Recommendation Report for Lawful Development Certificate for a Proposed Use or Development

REF NO: **AW/242/21/CLP**

LOCATION: 38 Carlton Avenue
 Aldwick
 PO21 3LP

PROPOSAL: Lawful development certificate for a proposed loft conversion & internal alterations.

Drawing Title:
PROPOSED PLANS, ELEVATIONS

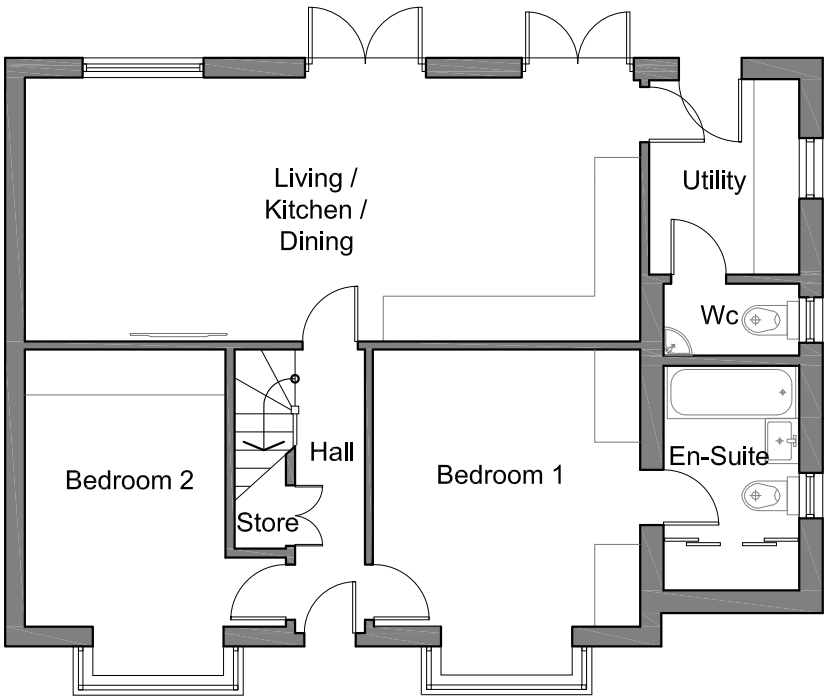
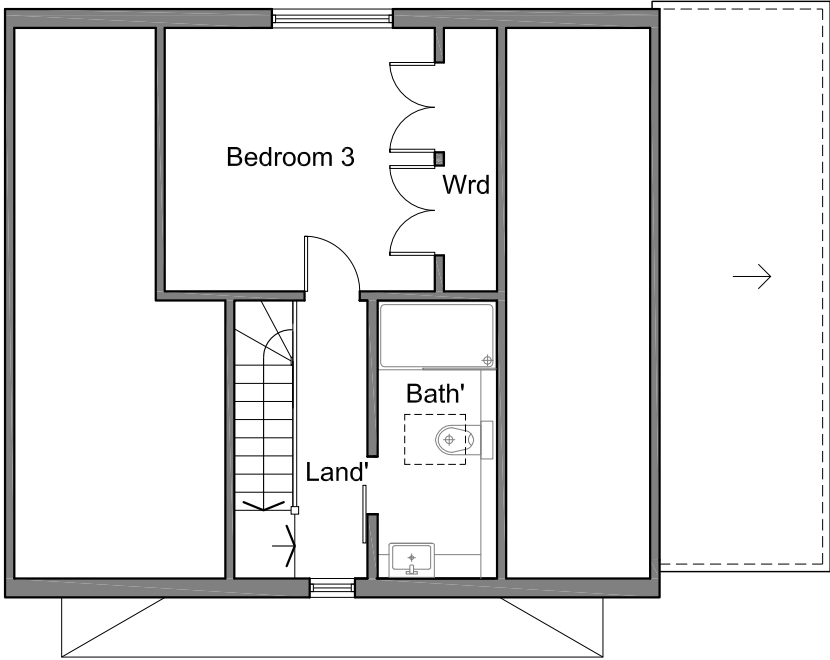
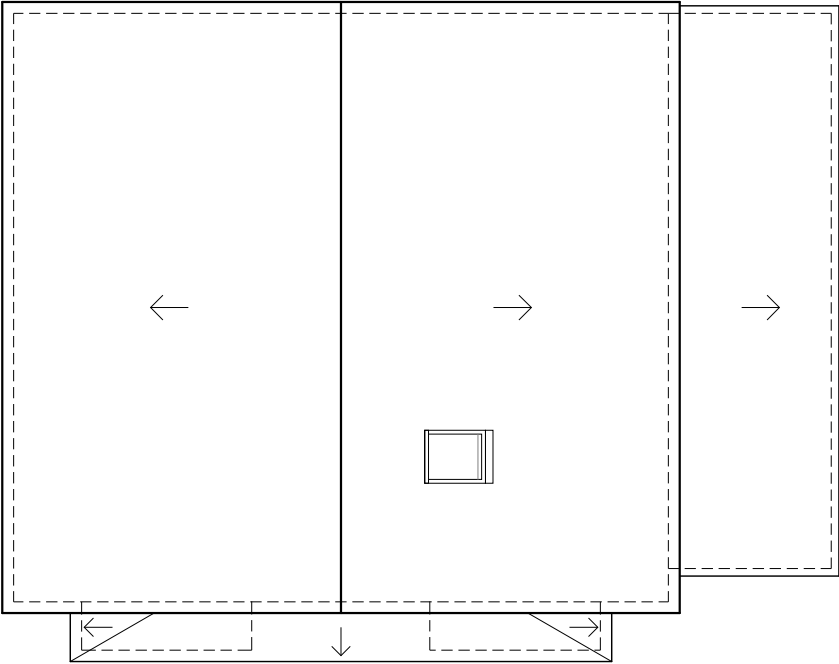
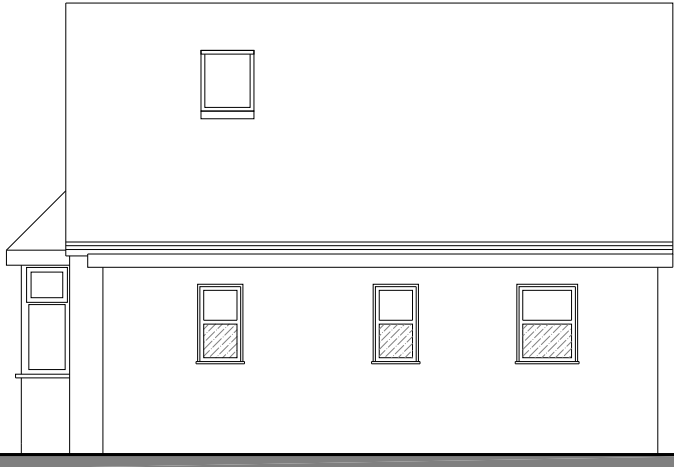
The proposed window and roof light complies with relevant sections A.3 (b) as it is not in a side elevation and C.1 and is considered permitted development and as such does not require the submission of an application for full planning permission.
